7 April 2016

Our Ref: 2016/169254
File No: R/2015/44/A
Your Ref: SSD 7431

RE: Exhibition of Sydney Opera House – Amendments to the Lower Concourse Restaurant Area (SSD 7431) - objection

Figure 6: Proposed glazing line and internal dining area configuration

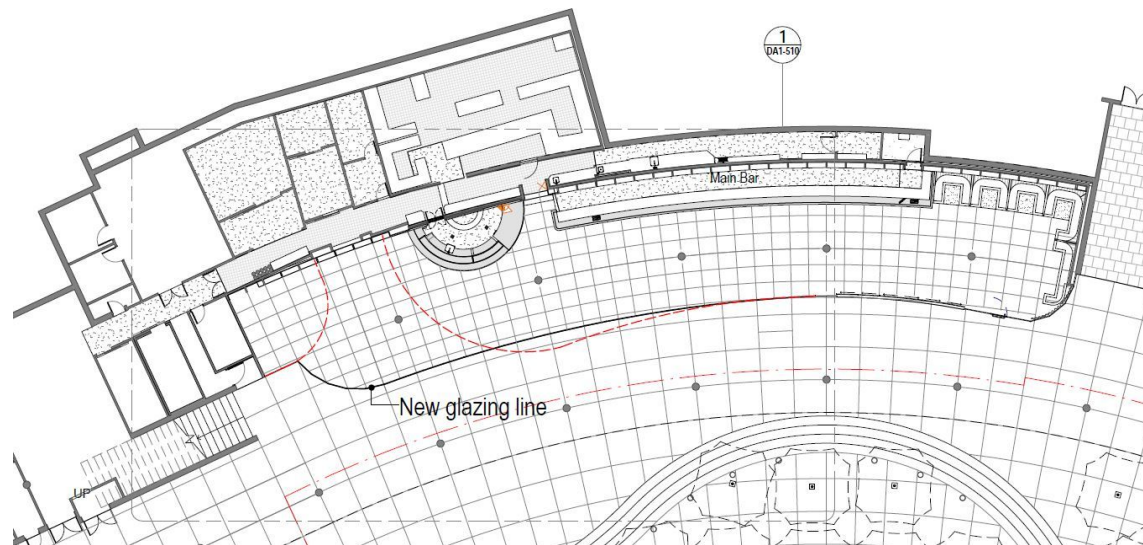
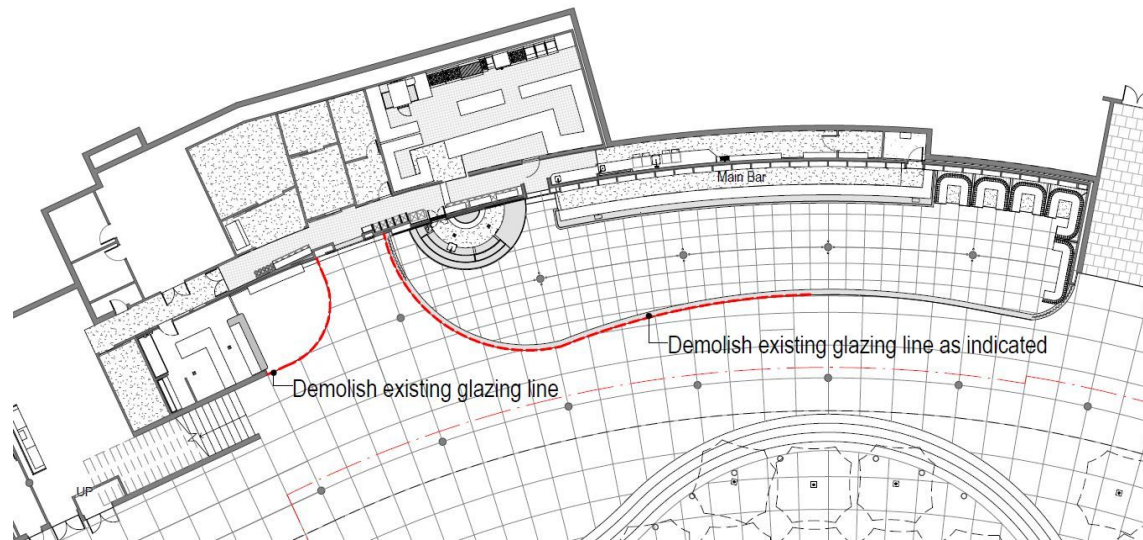
1. The proposed realignment of the line of glazing to enlarge the restaurant space marginalises the lower concourse landing area and has an adverse impact upon the connectivity between the lower concourse and the main western forecourt of the Sydney Opera House as follows:
 - a. The extended enclosure reduces the line of sight for visitors to access the stairs that connect the lower concourse to the main broadwalk of the Opera House.

- b. The extended enclosure impacts upon the ease in which visitors can access the stairs that connect the lower concourse to the main broadwalk of the Opera House.

- c. The realignment privatises additional space on the lower concourse and disrupts the easy flow of pedestrians.
2. The realignment is contrary to the intent of the Conservation Management Plan (2003, 3rd Edition), Policy 3.3 that states that '*Objects should only be permitted on the forecourt, lower forecourt sea wall path, broadwalk, podium deck and steps, if they do not interrupt or intrude upon the open and uncluttered character of the place, or if they are absolutely necessary for the safety of visitors.*'

- The proposal should be amended to avoid the additional privatisation of the lower concourse and to maintain sight lines and ease of access to the stairs connecting the lower concourse to the main broadwalk of the Opera House.
- The above could be achieved by redesigning the line of glazing to maintain sight lines and ease of access to the stairs connecting the lower concourse to the main broadwalk of the Opera House, by incorporating a concave curvature in lieu of the bulbous form proposed. This is illustrated in Attachment A.
